EPA Advice on Modification Application - MOD 16 - NTSF hydrocyclone sands buttressing - MP06_0295-Mod-16

I am writing in response to your request for the NSW Environment Protection Authority (EPA) to review the Modification Application for the proposed MOD 16 - NTSF hydrocyclone sands buttressing - MP06_0295-Mod-16 located at 1460 Cadia Rd, Orange, NSW (Premises).

Attachment A – NSW EPA detailed comments on Modification Report - MOD 16 - NTSF hydrocyclone sands buttressing - MP06_0295-Mod-16

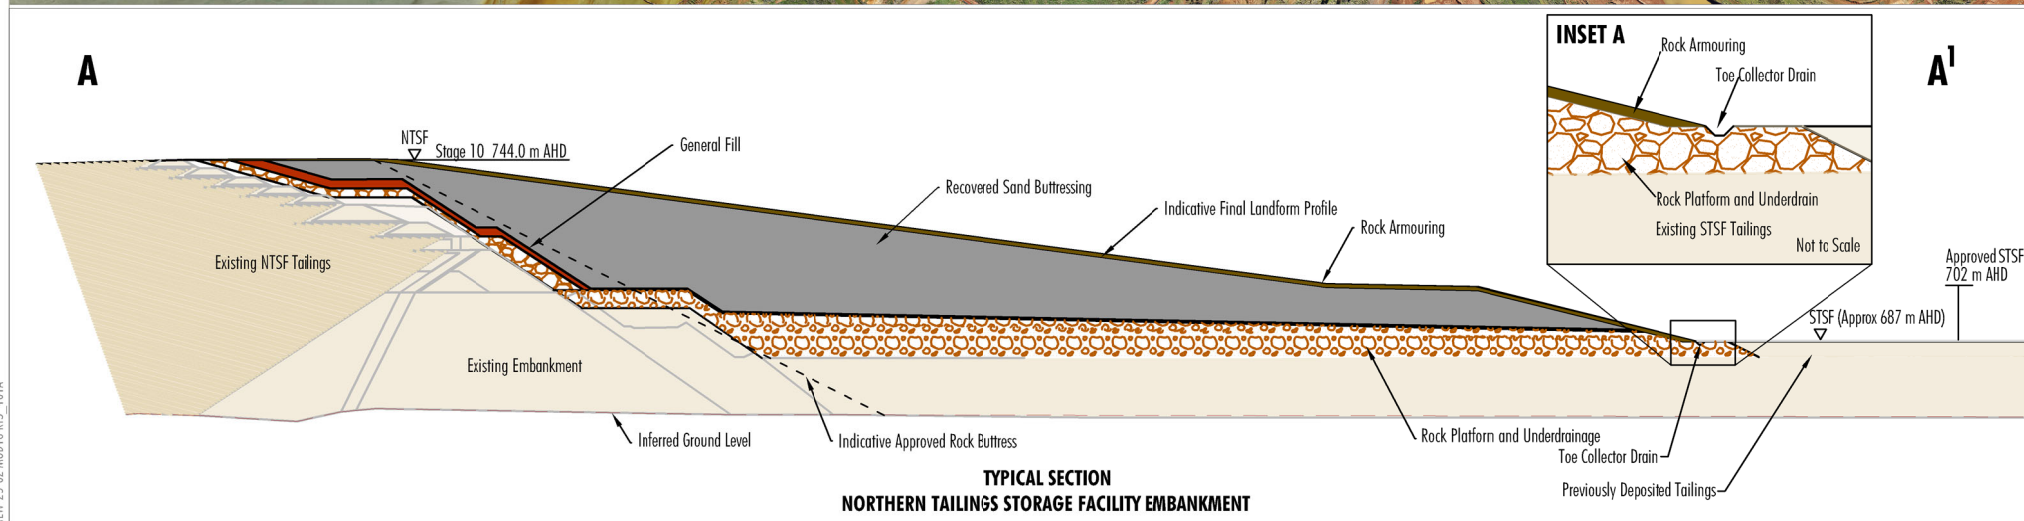
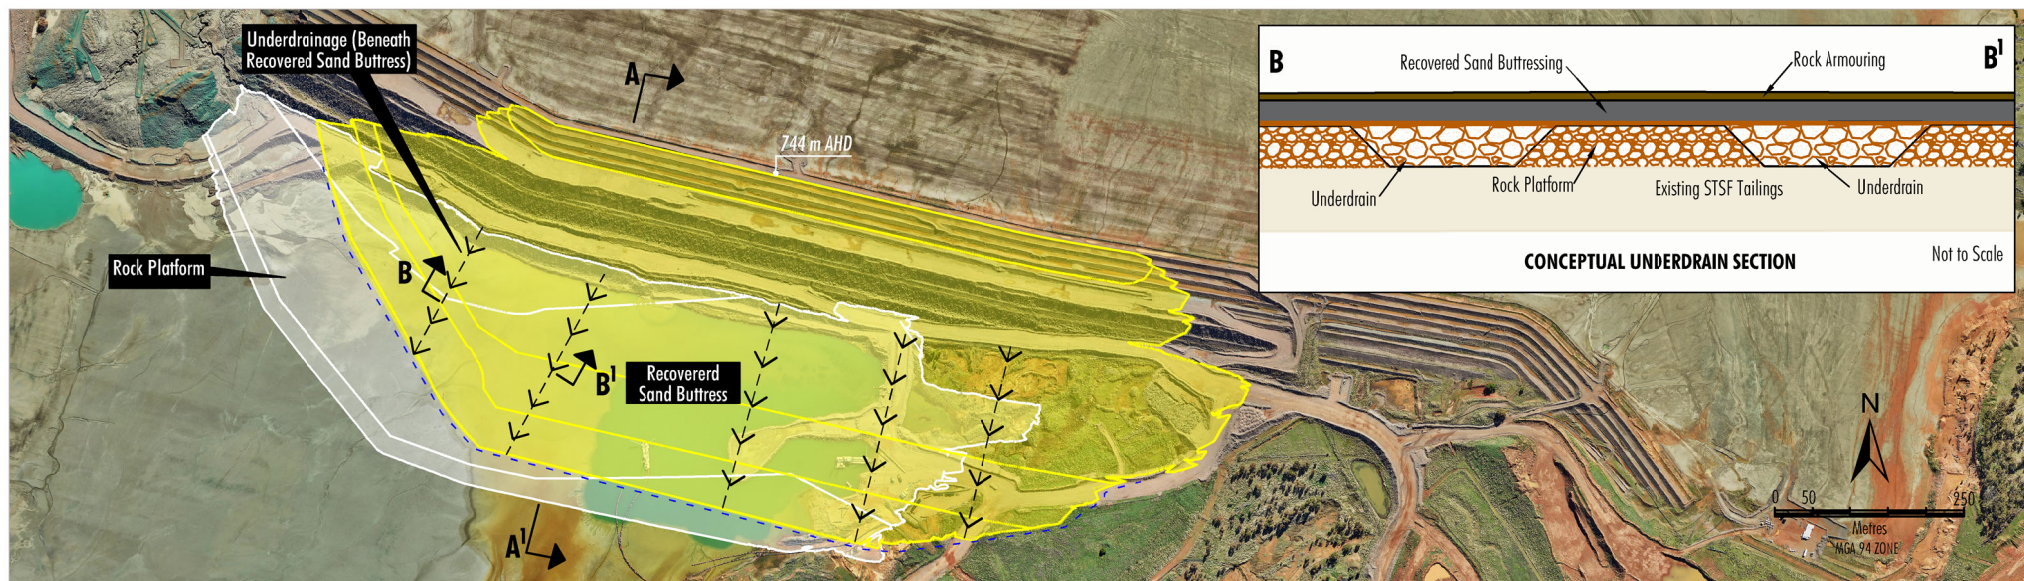
The EPA notes from Section 3.2.5 Rock Armouring that the recovered sand buttress will be covered with a layer of rock, and Section 3.2.6 Buttress Rehabilitation mentions the capping with topsoil for revegetation.

The EPA acknowledges the intention of the rock armouring and buttress rehabilitation. However, the activity may generate dust during the construction phase, with the potential for off-site impacts in the short- to longer-term, which must be appropriately managed. Also, the length of time of sand exposure prior to rock capping and revegetation may increase the risk of particulate matter migrating from the site.

The EPA recommends DPHI seeks further information on the design of the rock armouring and details of the proposed capping, such as layering and thickness, including any mitigation measures proposed during construction. The EPA also requests information on the length of time of sand exposure on the tailings dam walls and any required mitigation measures to ensure dust generation of these exposed areas is appropriately managed. The EPA may require revision of the air quality impact assessment depending on the information provided by the Applicant.
